**Our Ref: R/68/13/  
Your Ref:**

**Application for Planning Permission for Works or Extension to a Dwelling**

**Development** Side and rear extension  
**Location** 32 Tennyson Avenue Rustington Littlehampton

EXISTING REAR ELEVATION

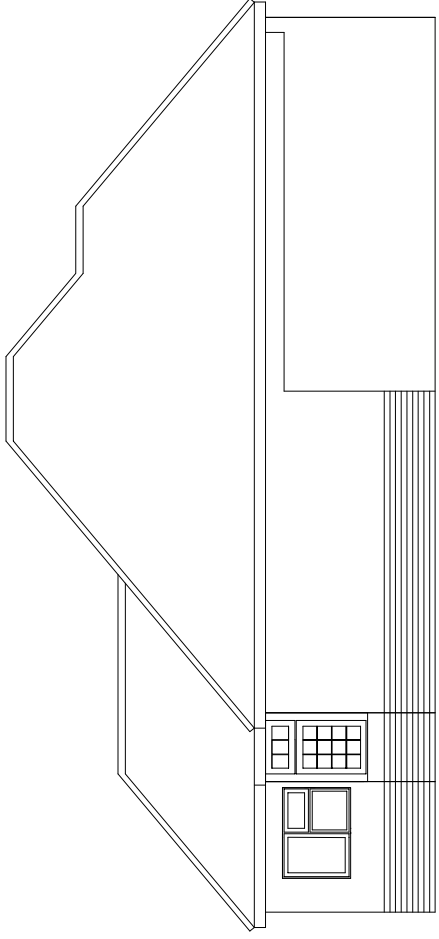
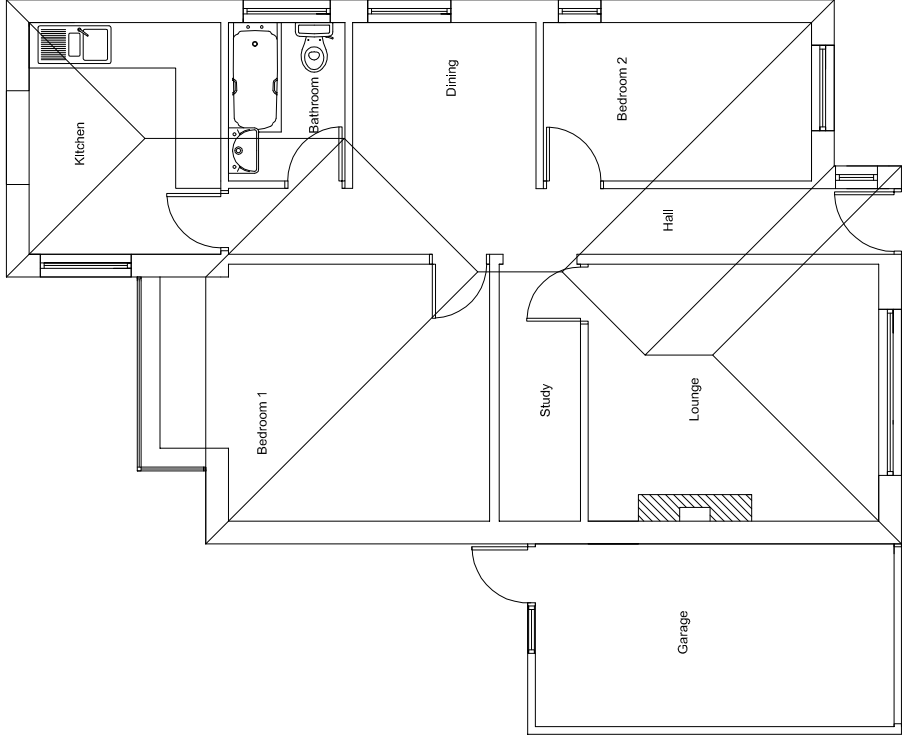
The existing rear elevation and existing rear floor plan do not accord. Please amend accordingly.

BLOCK PLAN 1:500 @ A2

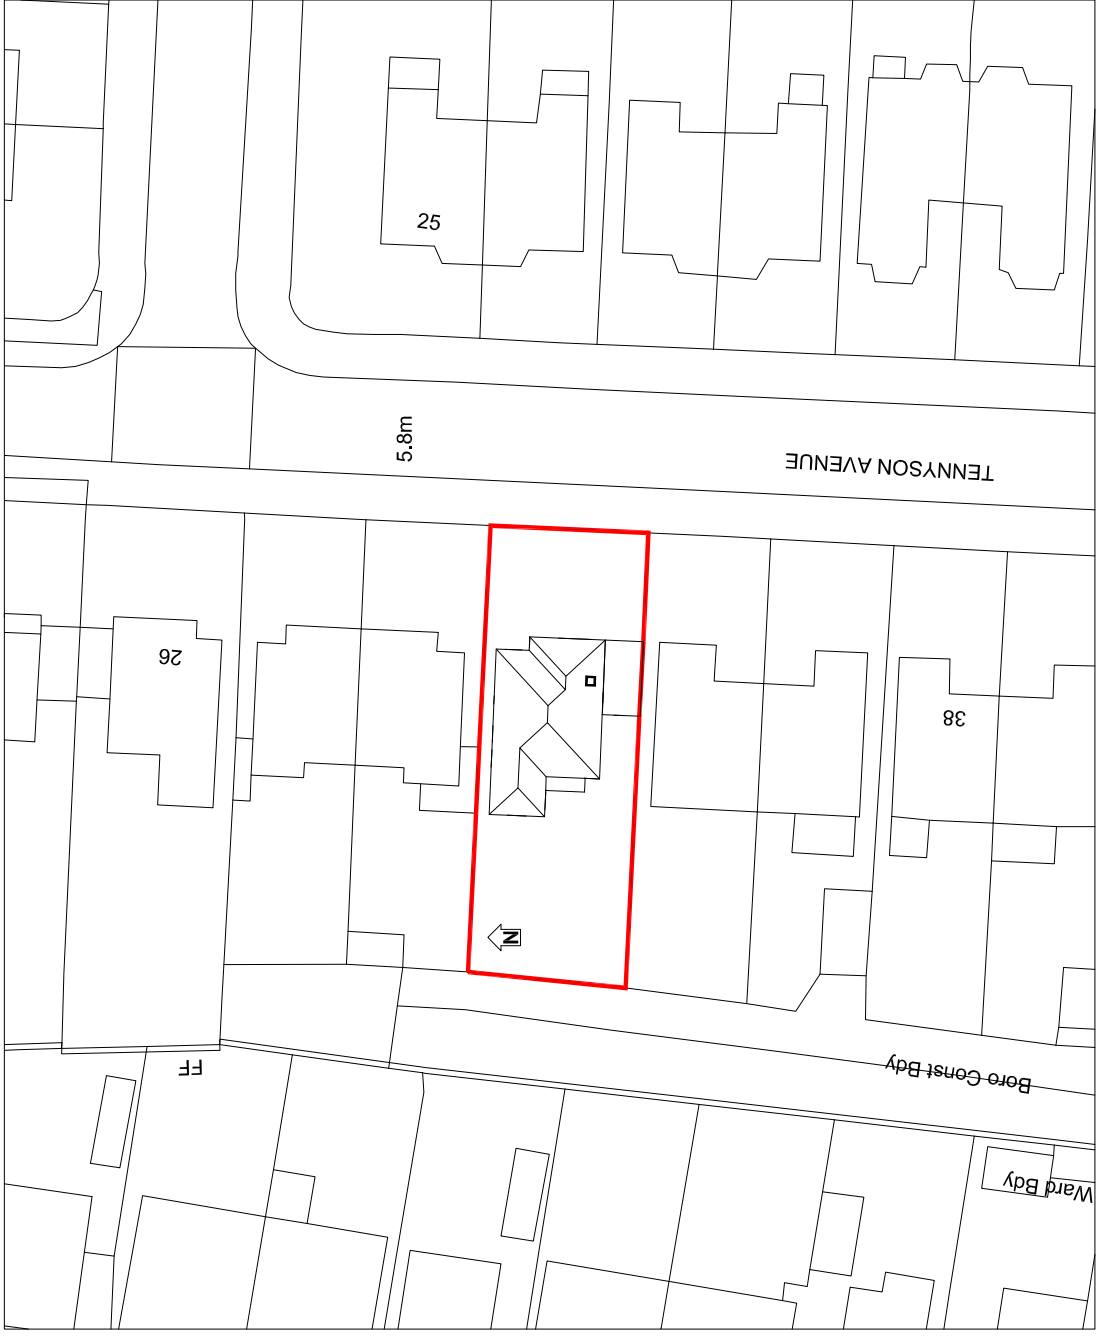
One of the block plans does not scale properly. Please amend the incorrect one accordingly.
